From: Simon Davis
Sent: 12 February 2019 15:44
To: 'Kathryn Griffiths' [REDACTED]
Cc: 'Zoe Knott' [REDACTED]
Subject: Burndell Road - Y/98/18/RES - boundary treatments

BOVIS HOMES
scheme: Land off Burndell Road
Yapton
client: Bovis Homes
drawing: Hard Landscape Proposals
date: Nov. 2018
scale: 1:200@A1
drawing no: BOV22172 12E sheet 3
drawn: AE checked: DKM

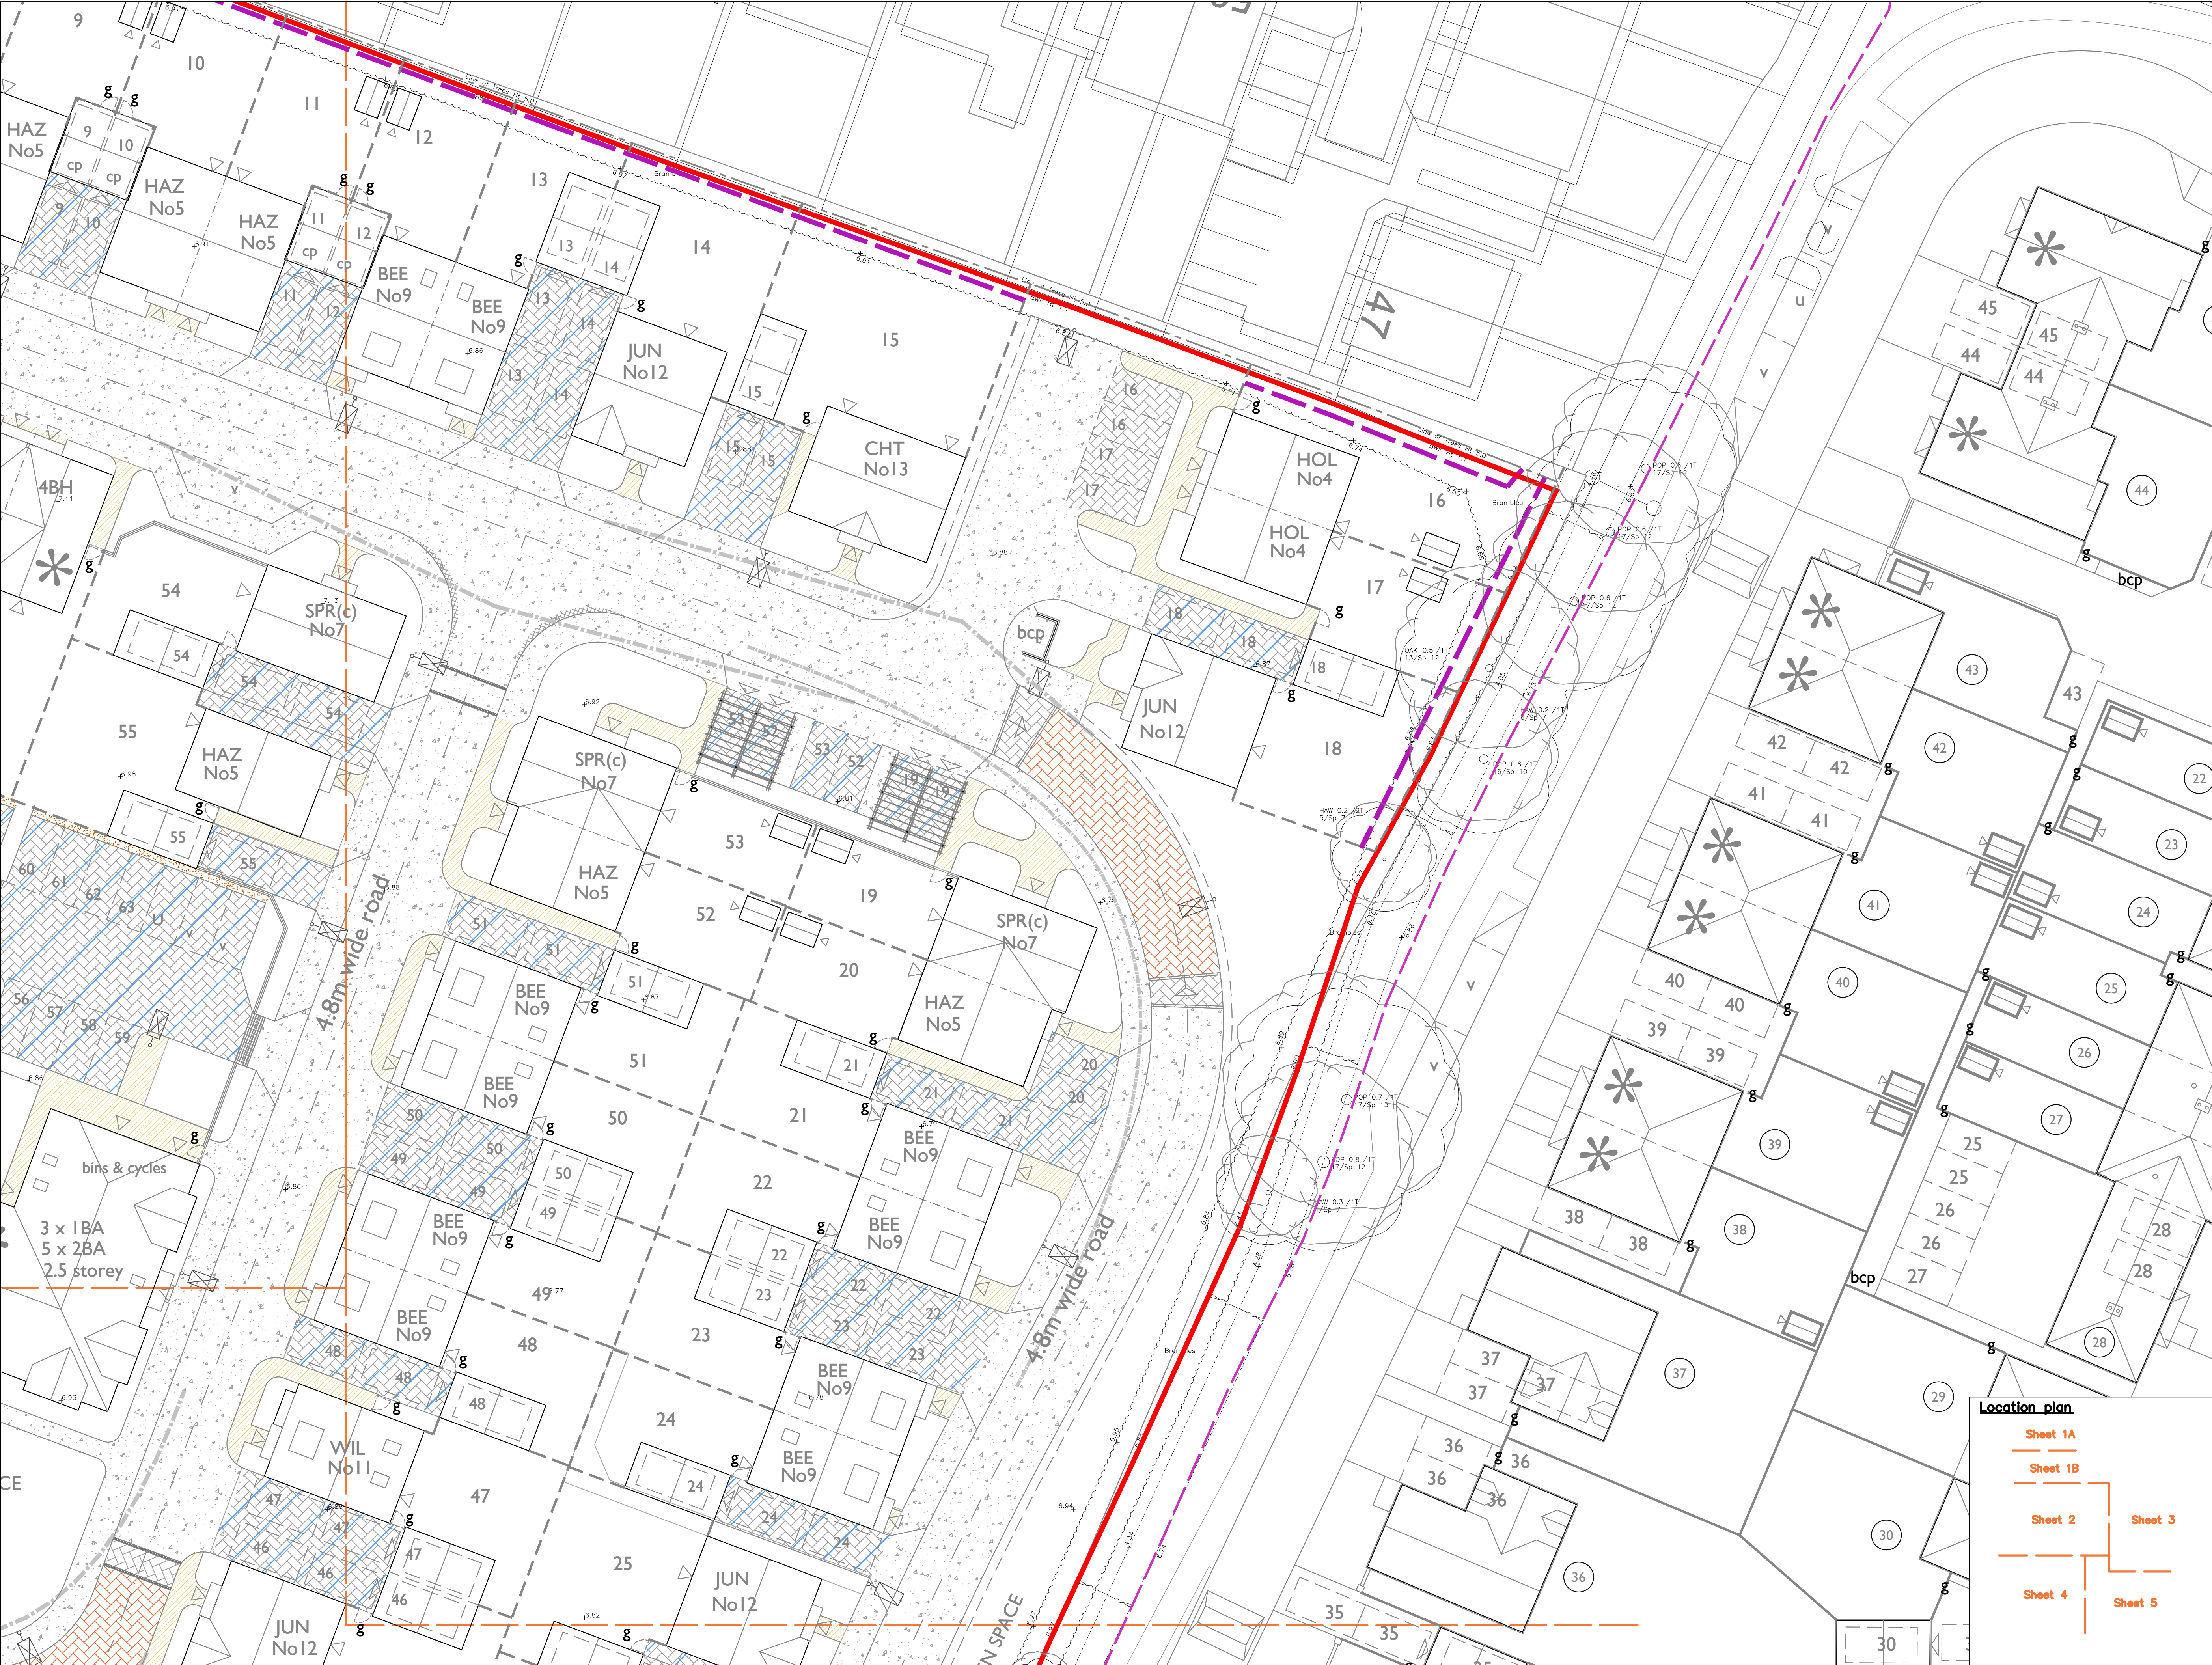
I have just had a call from the owner of 22 Fellows Gardens. He is concerned about security to his property during construction and also post completion until such time as the landscaping grows & matures in respect of his western boundary. He says he currently only has a timber fence less than 1.8m and would like a new fence erecting (or perhaps you might offer to increase the height of his existing fence). I told him I would raise this with you.
